**KIRKLEES METROPOLITAN COUNCIL
INVESTMENT & REGENERATION SERVICE**

DELEGATED DECISION TO DETERMINE PLANNING APPLICATIONS

Reference No: 2020/62/93868/W

Description: Erection of single and two storey extensions

| DRAWING TITLE<br>PROPOSED PLANS                                                                                                                                                                                                                                      |       |             |            |

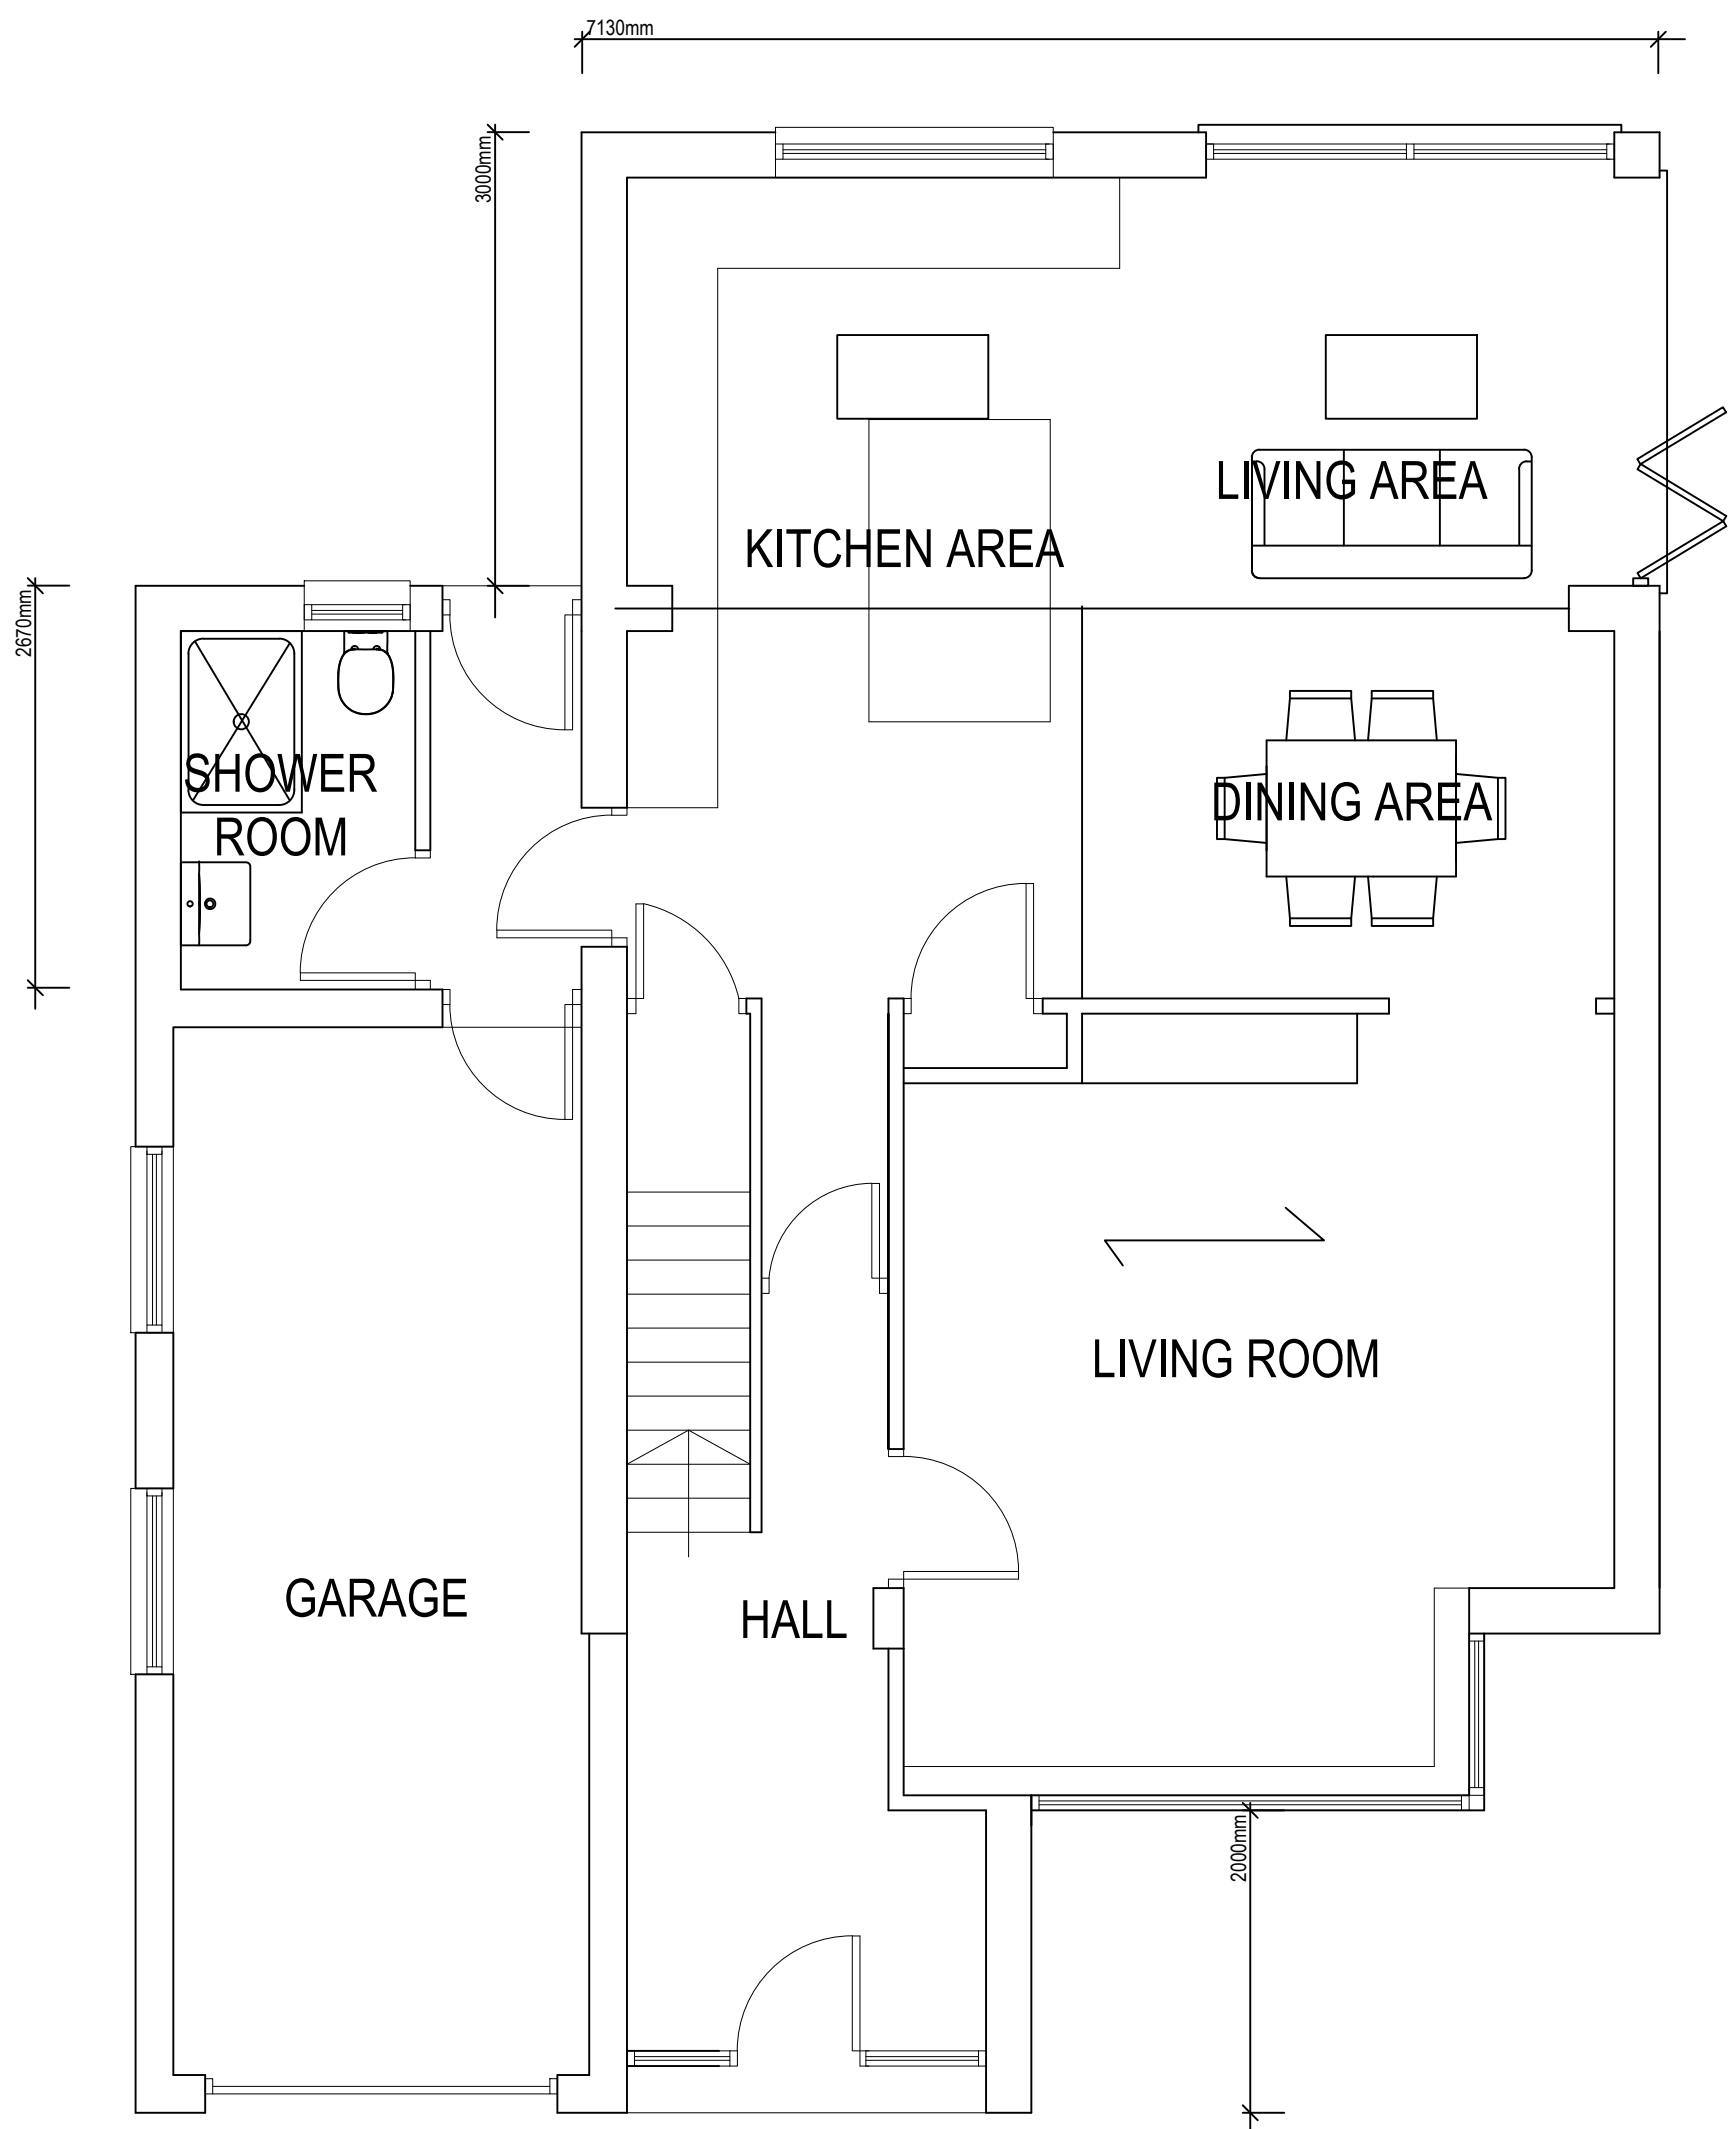
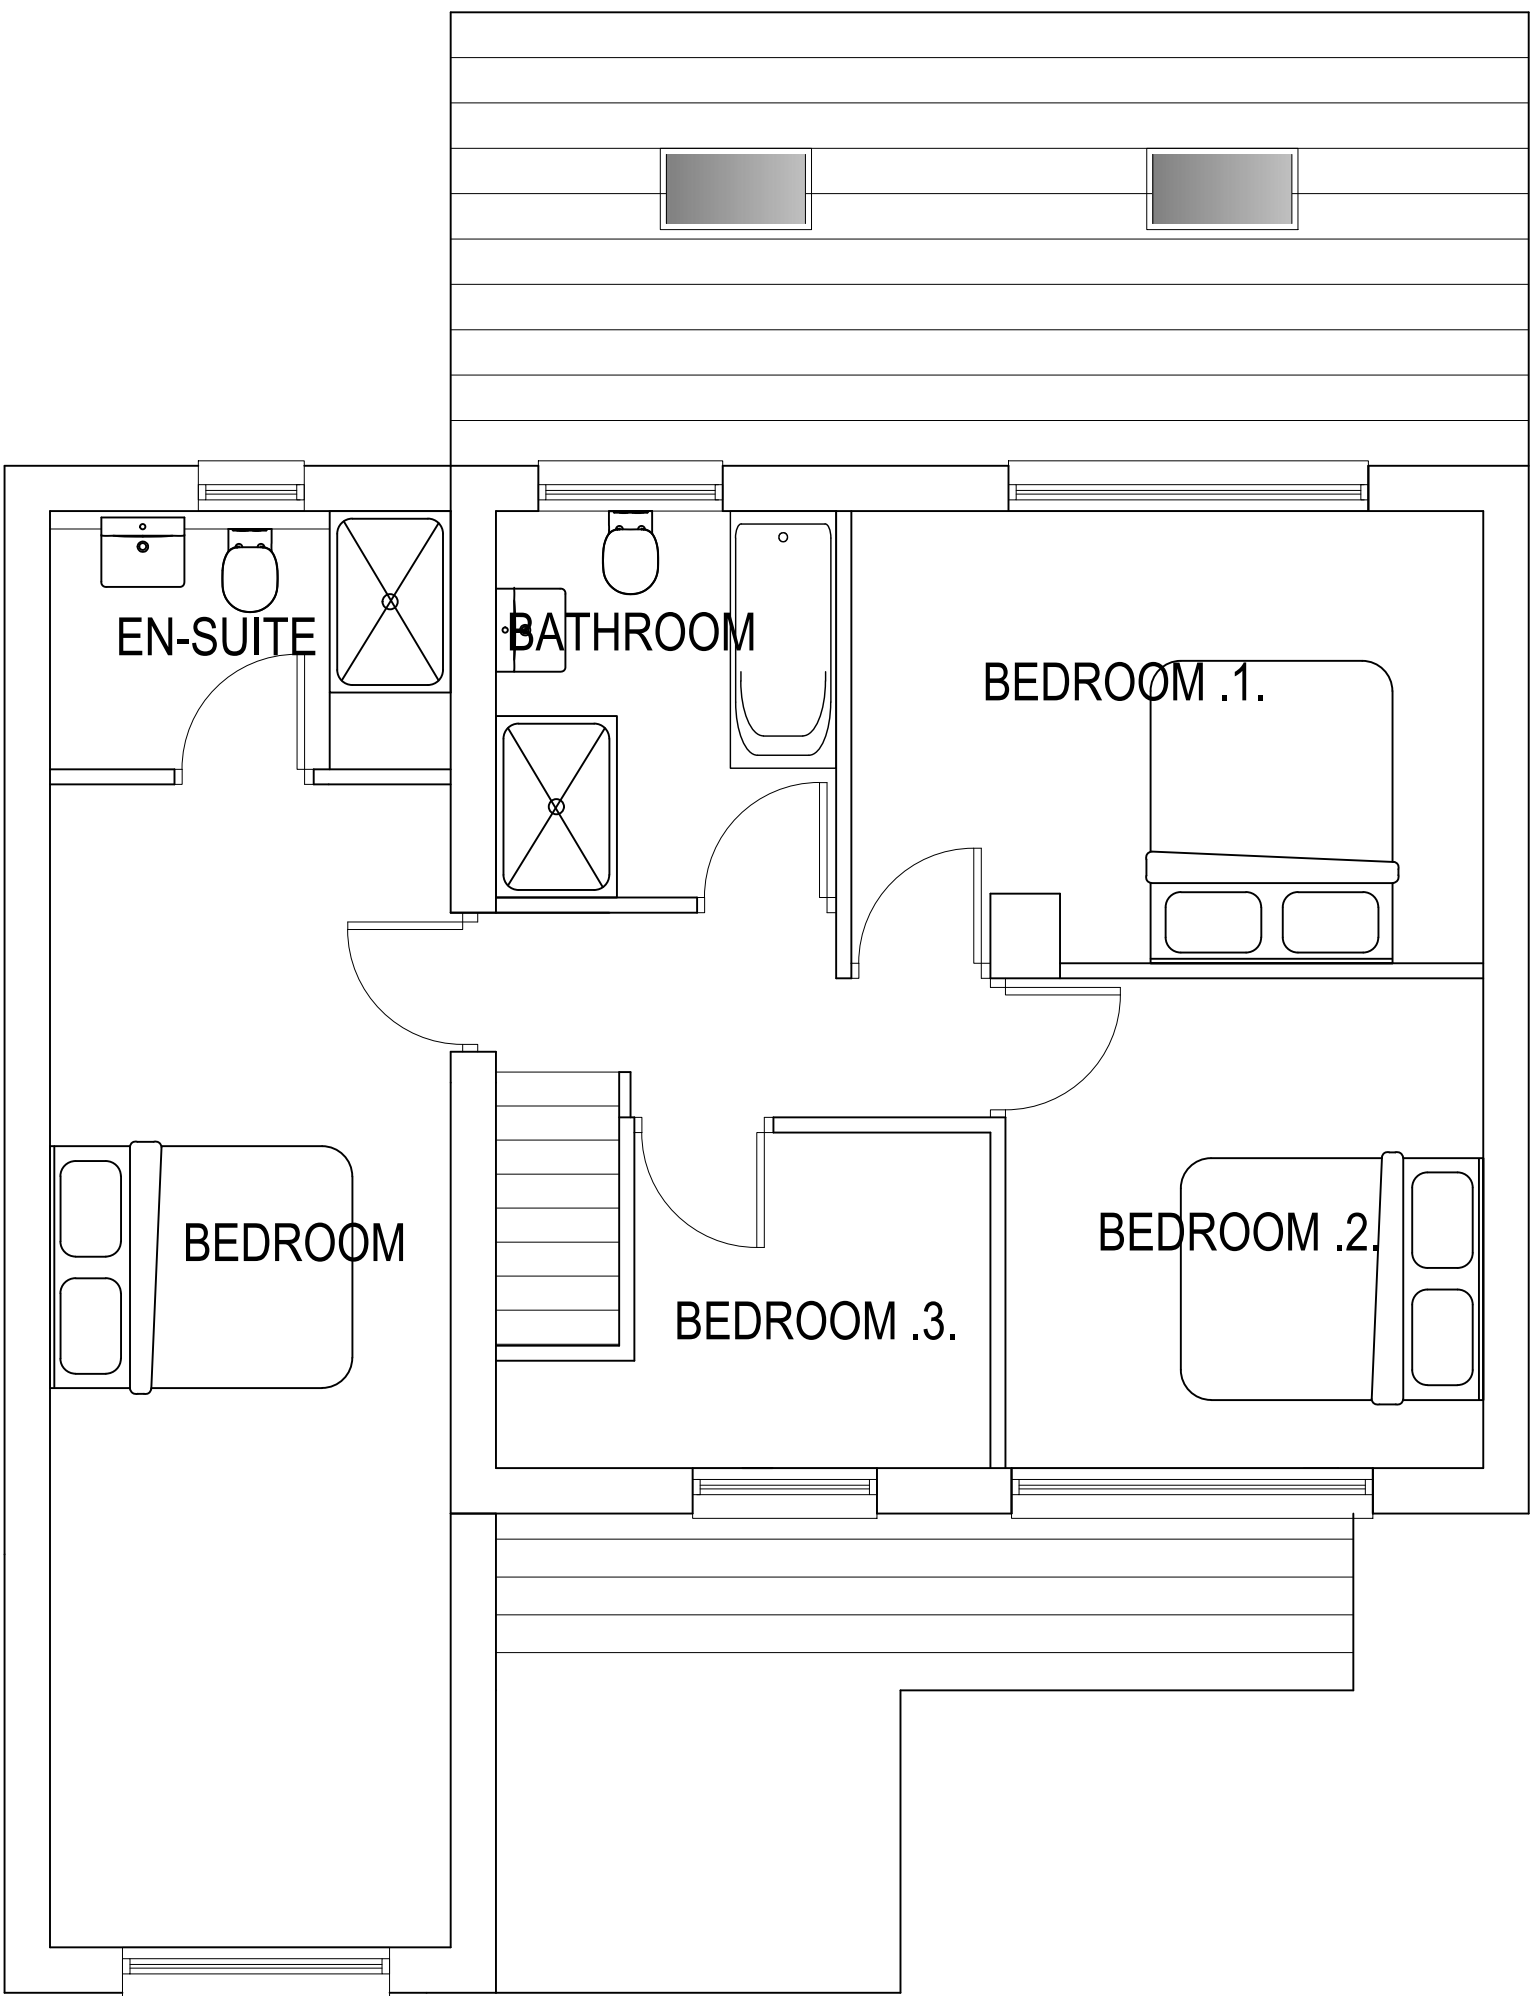
- *60 Southfield Road* – this property is located to the east of the application site. This neighbouring property is located next to the site of the proposed two storey side extension at 58 Southfield Road. However, the side extension is set back from the eastern side boundary of the application site by 1.00 metre, therefore, retaining separation distance with regard to this neighbouring property, especially when the neighbouring driveway is also taken into consideration. Although the proposed side extension is two-storey, it will not result in undue overbearing because the proposed length and height of the side extension does not exceed the length and height of the dwelling erected at present and therefore, the increase in bulking and massing is subservient when the development is viewed in conjunction with the dominant dwellinghouse. In addition, the extension would not result in undue overshadowing to this neighbouring property, a sunlight calculator has been used to confirm this. In the winter no overshadowing would be caused as the sun doesn't move to a position of potential overshadowing during sunlight hours and in the summer the process of shadowing begins to occur marginally at 6:30pm but does intensify until 8:00pm. Furthermore, it should be acknowledged that this overshadowing analysis is in regard to the neighbouring dwelling and at no time will the extension cause overshadowing to the neighbouring garden. Furthermore, although two windows are proposed on the ground floor side elevation, these are proposed in conjunction with the garage and not a living area within the property and therefore, will not impact negatively upon neighbouring privacy. The proposed single storey extension to the rear will not be obtrusive and will cause no undue overbearing or overshadowing with regard to the neighbouring property of 60 Southfield Road. Furthermore, the neighbouring property has an outhouse erected in their rear garden that will further mitigate any potential impacts from the rear extension, acting as a form of boundary treatment. Finally, this rear extension will cause no impact upon neighbouring privacy because no glazing is proposed on the side extension facing this neighbouring property and therefore, the rear extension does not increase any potential overlooking.

One representation was received. The representation received stated that the proposed side extension appeared too big from looking at the proposed plans. Stating that it would have a dramatic effect on the lighting within the interior of the neighbouring property and that the whole property would become overshadowed. The representation also stated that the property would look like no other property in the vicinity.

Response: Upon assessment it was determined that the proposed side extension was not 'too big'. The host property is detached and has a large extent of available curtilage space within its boundaries, therefore, the addition of a two-storey extension to the front and side would not adversely affect the property visually. In addition, in terms of the neighbouring properties, a site visit was undertaken by the case officer and an assessment was made that the extension would not lead to undue overbearing or overshadowing. Finally, it has been acknowledged that although following development the property would be like no other in the vicinity, at present it is already an anomaly within the streetscene in regard to its design, size and scale.

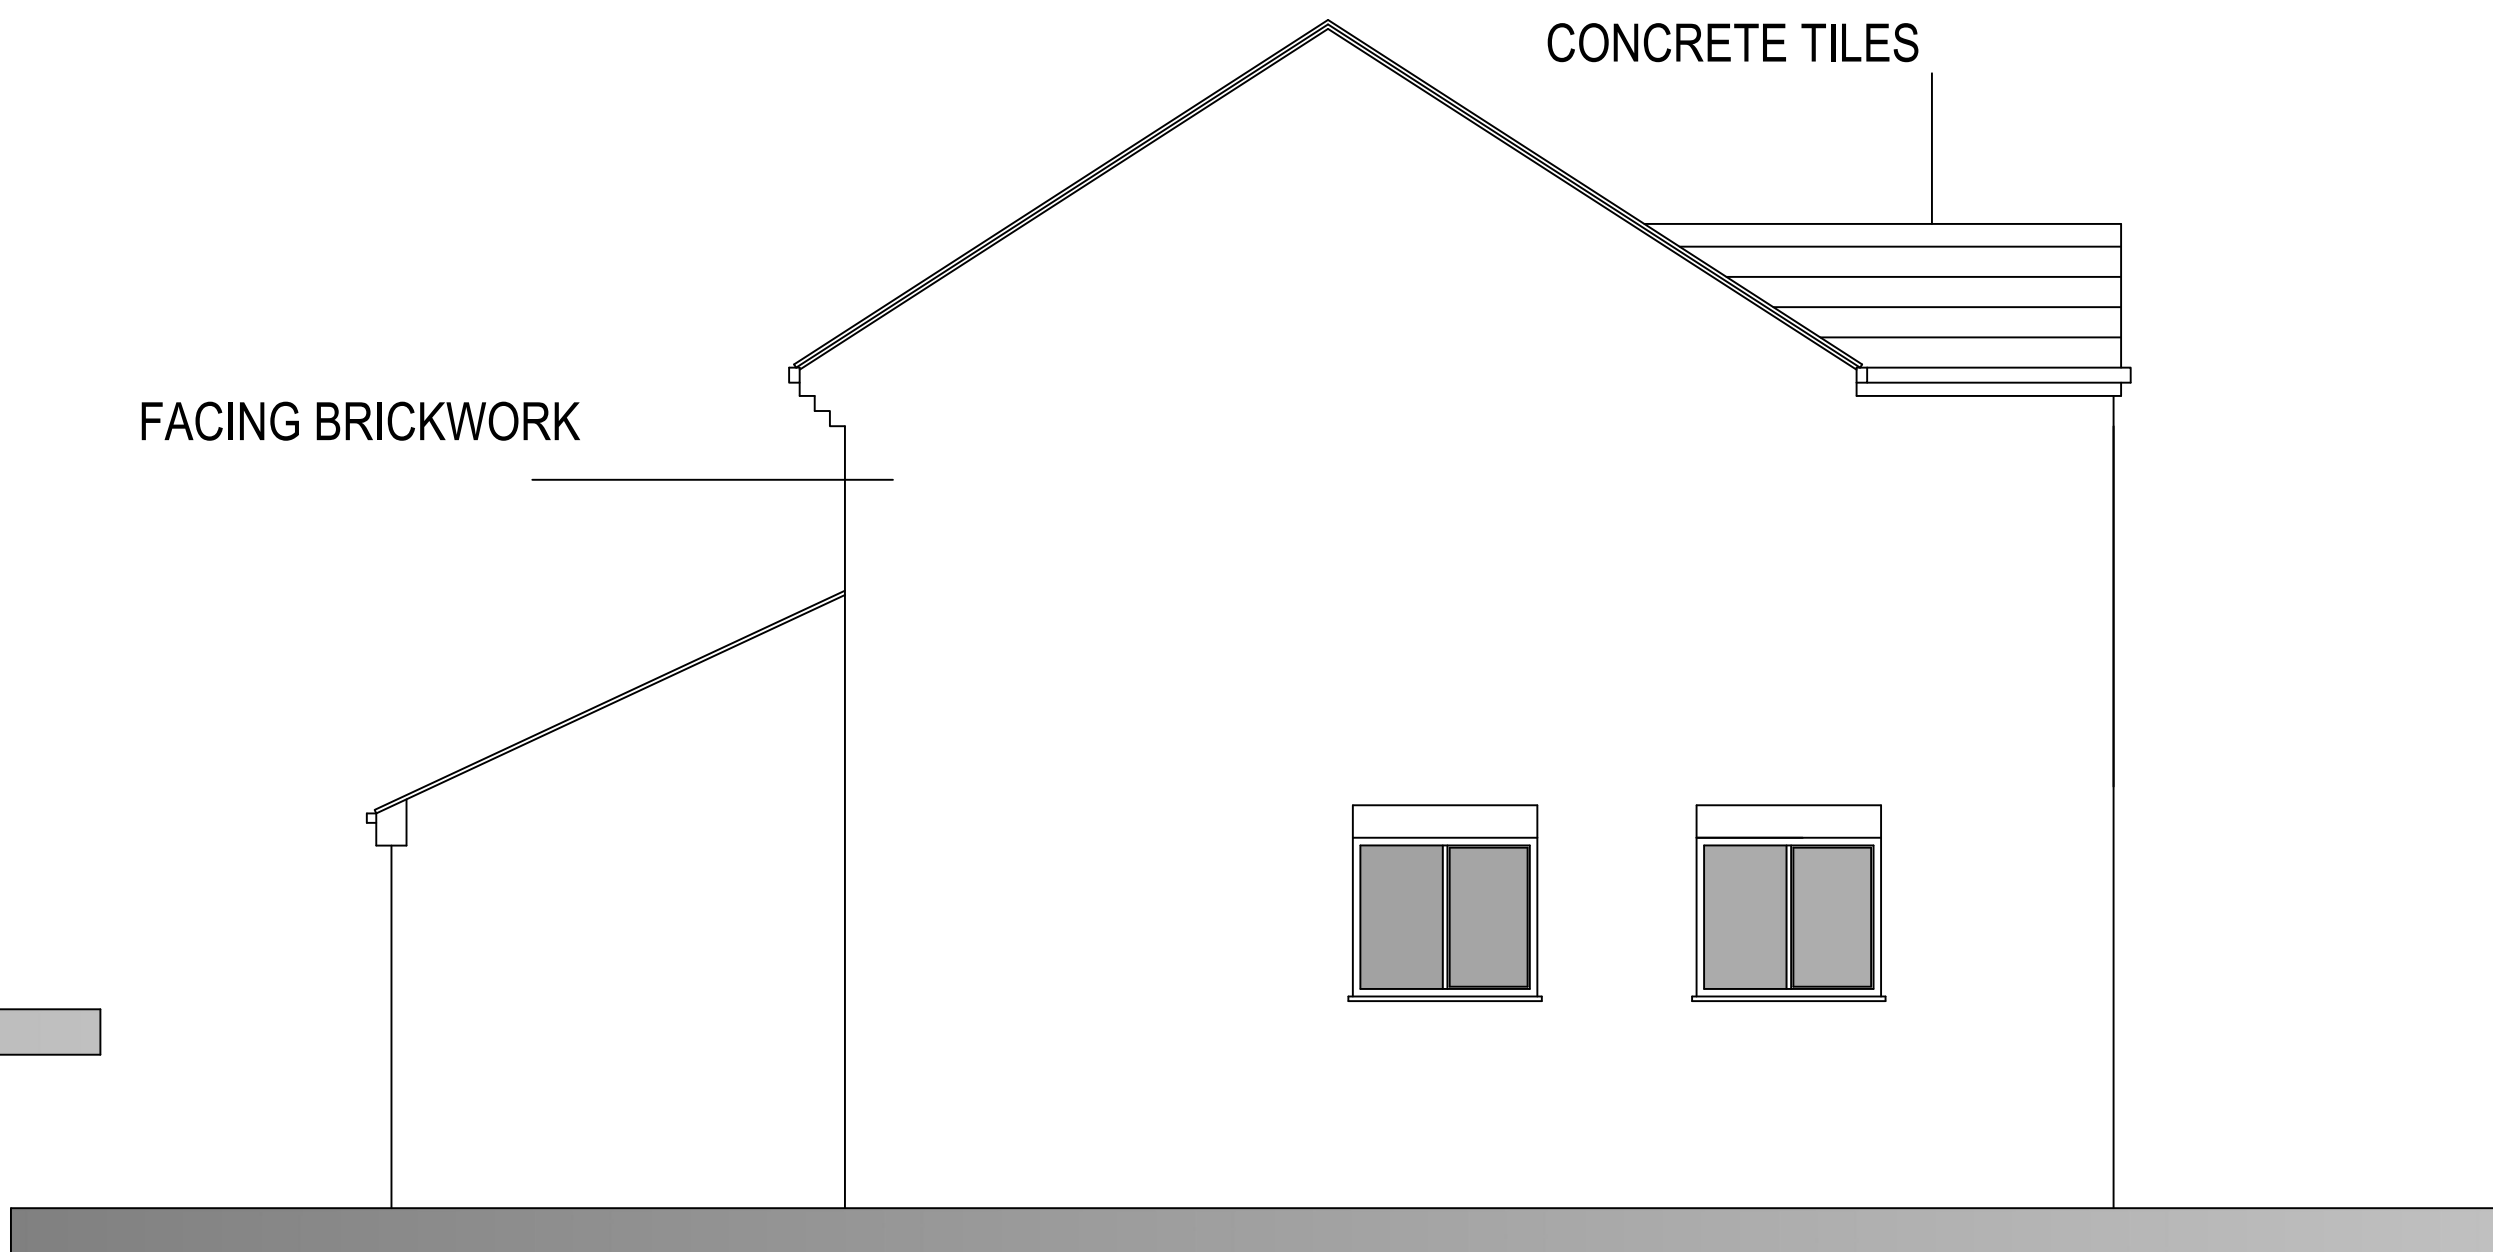
Officer sought design amendment to the front elevation and lean-to roof. A revised plan was received and forms part of the submitted details for assessment.

Amendments were sought, and new plans were submitted, however, the new plans were not re-advertised as the changes were minor and involved the proposed lean-to roof on the front elevation of the dwelling and additional

parking. In the original plans two smaller lean-to roofs were proposed above the separate amenity spaces of the hall area and living area. However, the amended plans showed a single adjoining lean to roof which is classified to be a more appropriate feature of development. Additionally, an increase in parking was deemed necessary at the property in line with K.C. highways advice.

The exterior alterations to the front elevation include the erection of a lean-to roof at the single-storey level of the dwelling. This can be considered to be an appropriate addition to the dwelling and will be a more visually appropriate development in comparison with the flat roof erected at present. This roof will be infilled with concrete tiles and will therefore, correspond to the roofing style of the dominant dwellinghouse and the proposed side and rear extensions. In addition, the proposed alterations to fenestration detailing on the front elevation, will ensure coordination throughout the development process, ensuring all fenestration detailing is constructed from grey UPVC. The two new windows to be erected on the western side elevation will also coordinate with other details on the property.
